BILLINGTON AND LANGHO PARISH COUNCIL

The parish council wish to comment on the following applications as follows,

3/2012/0225 – All weather football pitch with associated works at Langho Football Club, Dewhurst Road.

DRAWING TITLE	LAYOUT PLAN PROPOSED FLOODLIT SYNTHETIC TURF PITCH
---------------	---

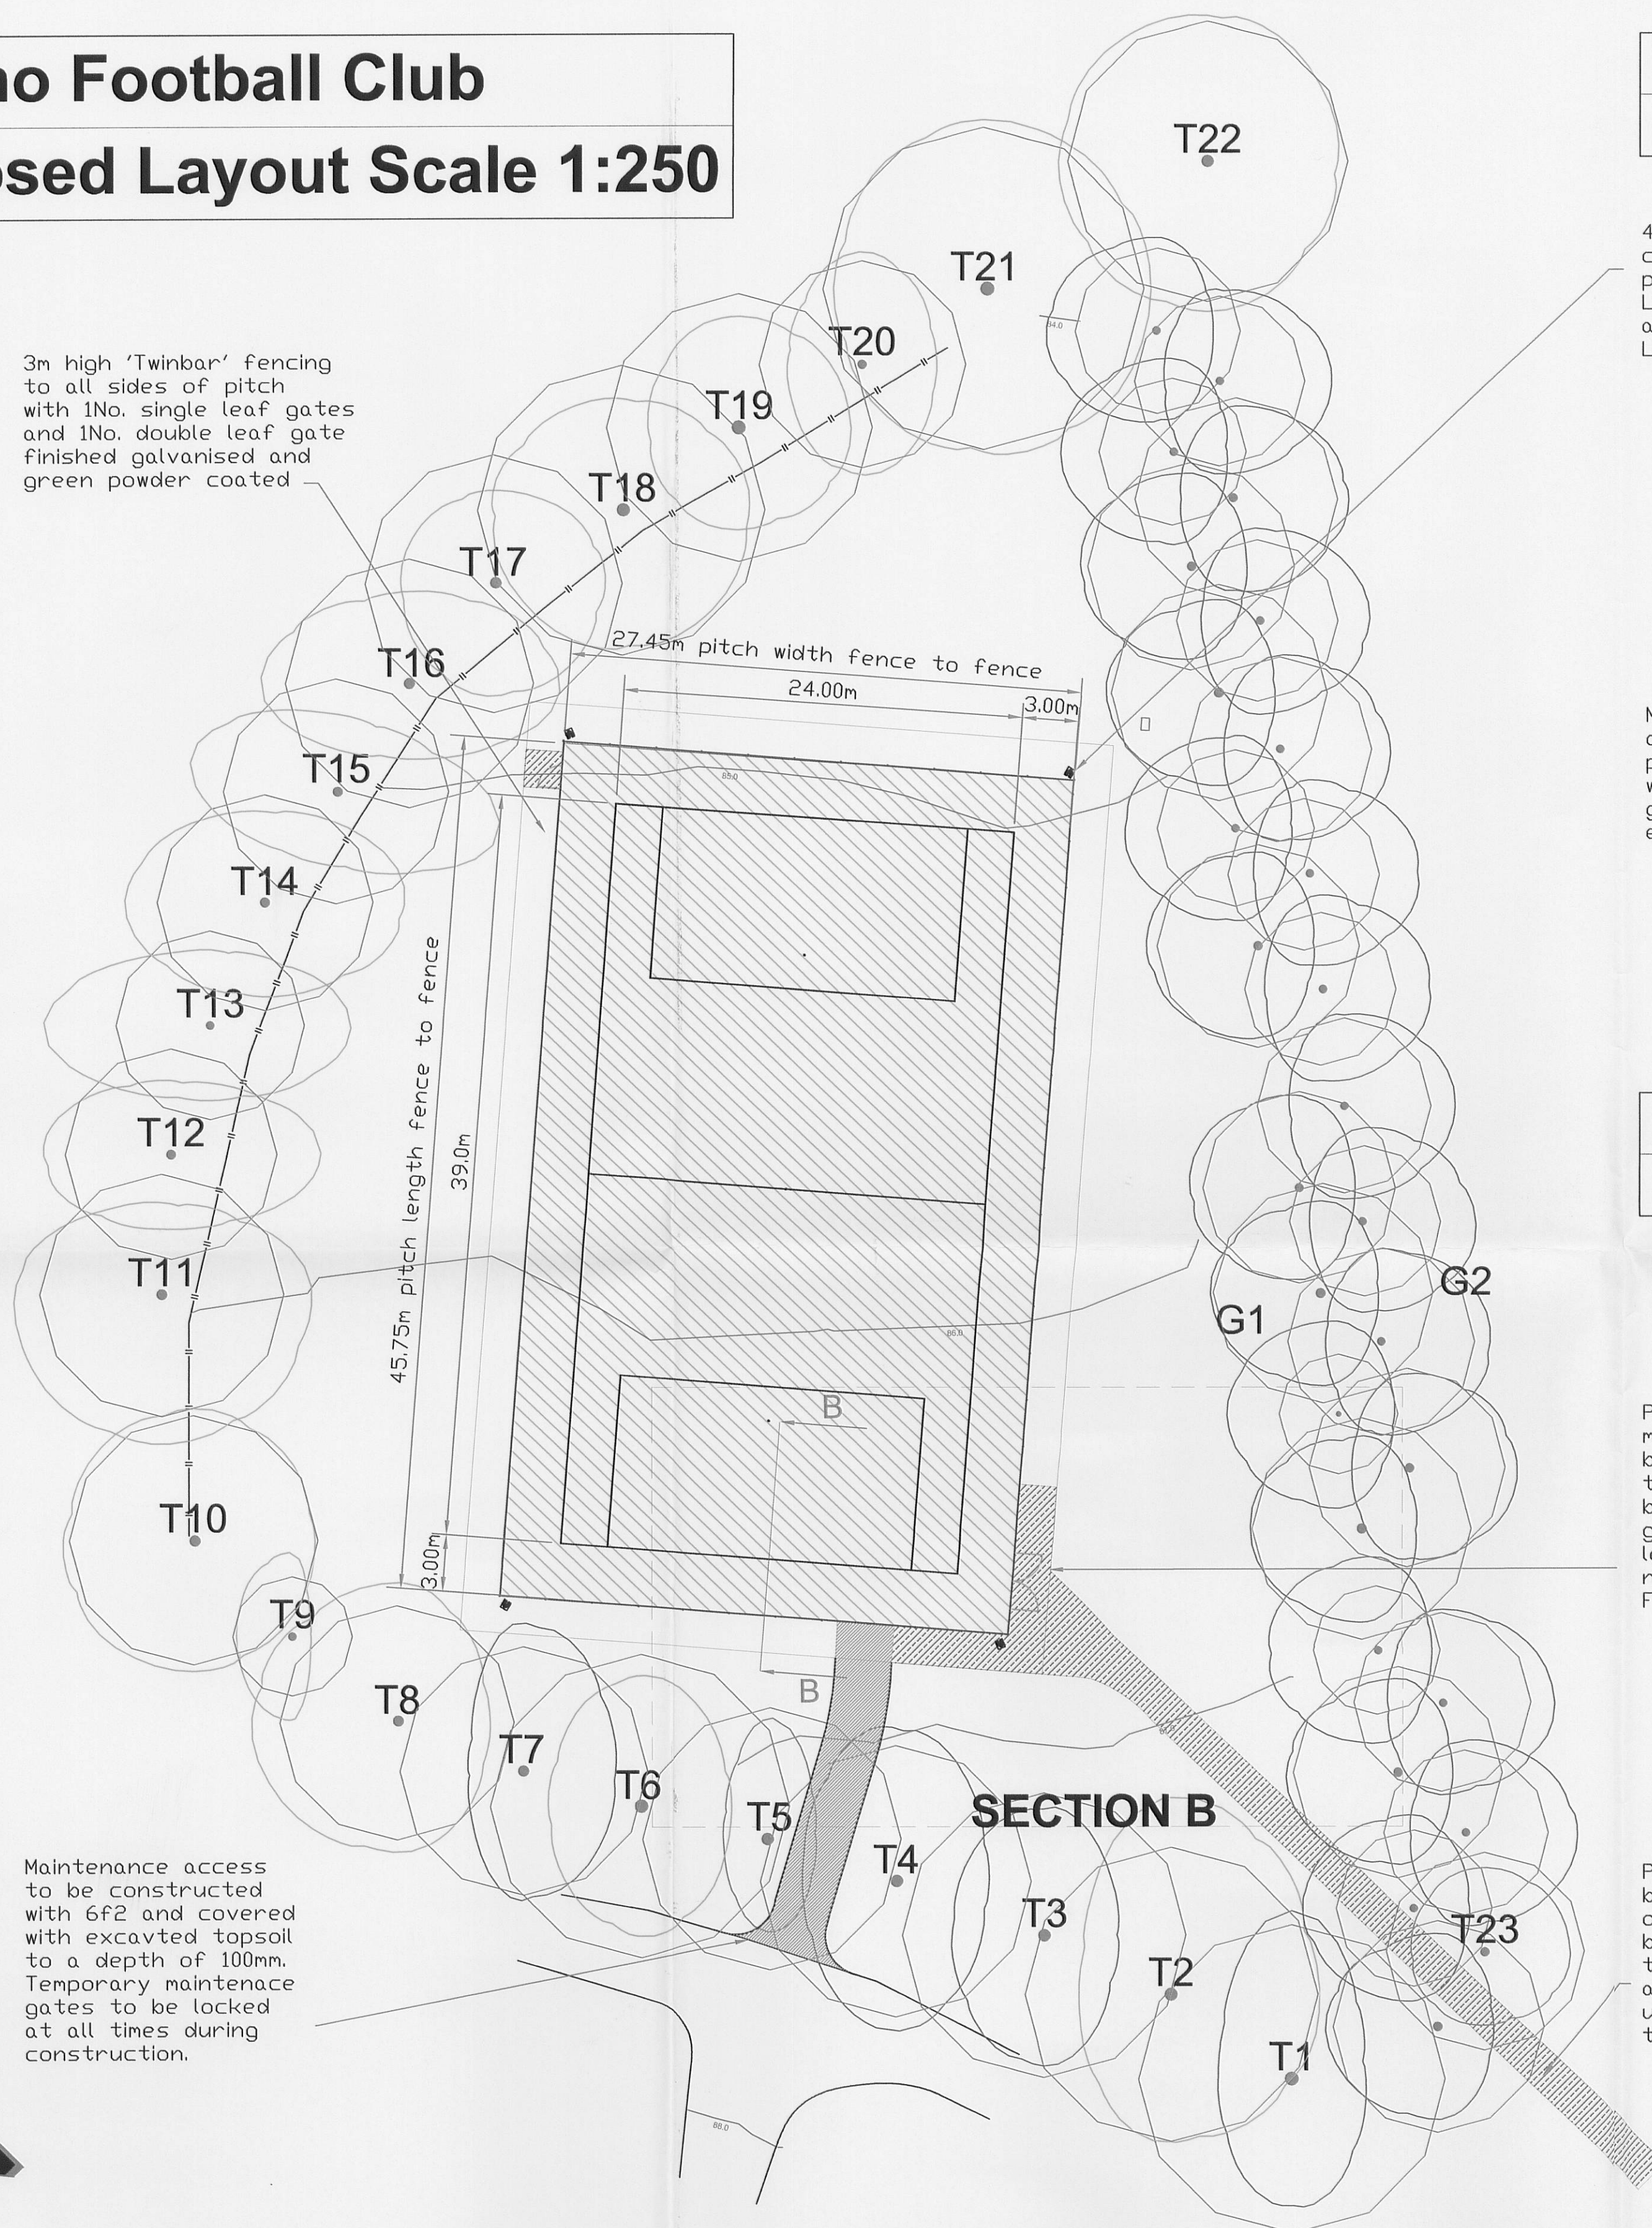
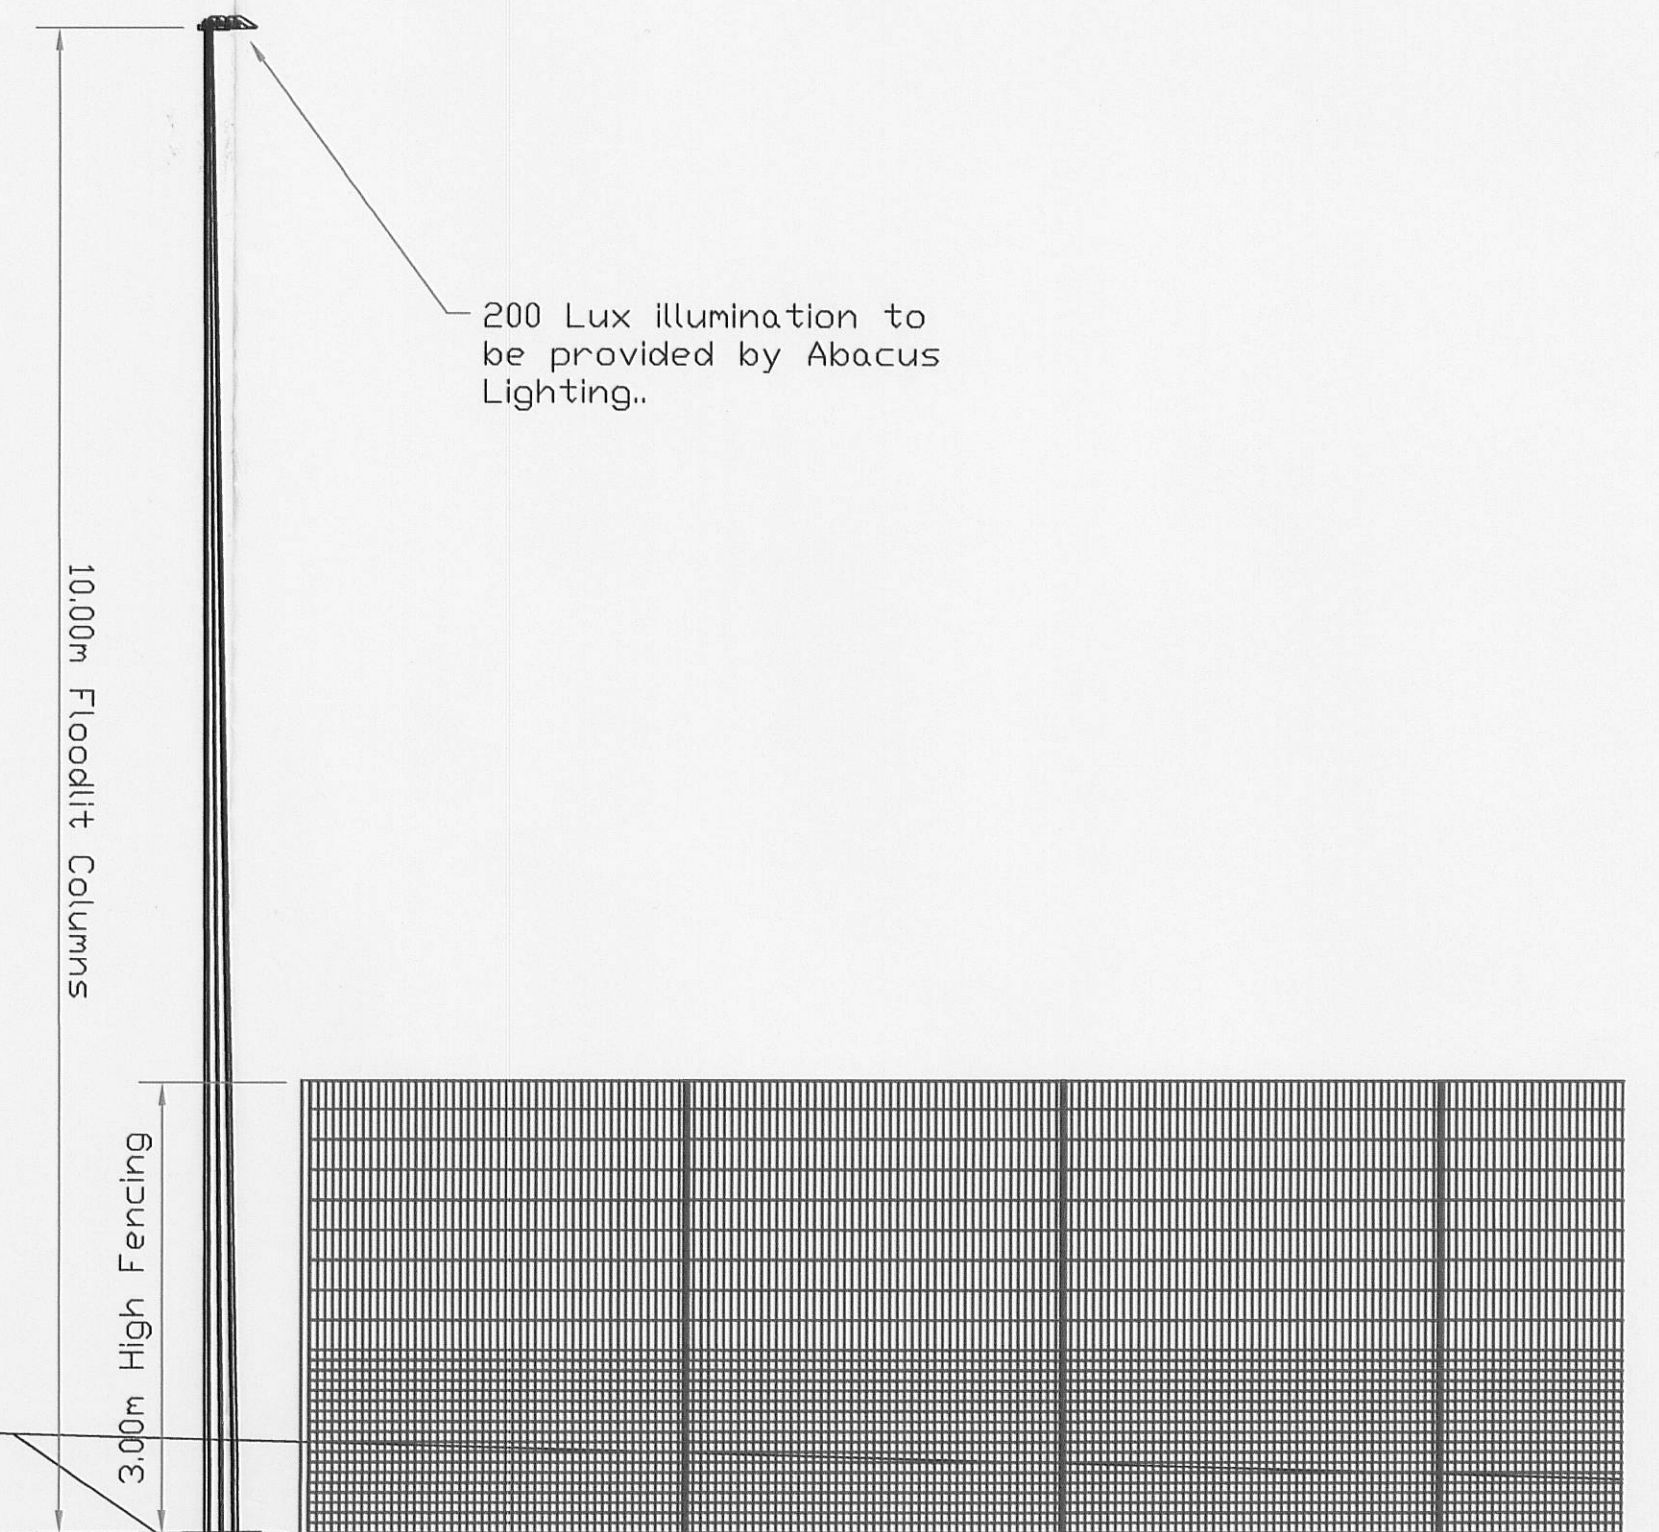
No objections in principle providing there will be no light pollution.
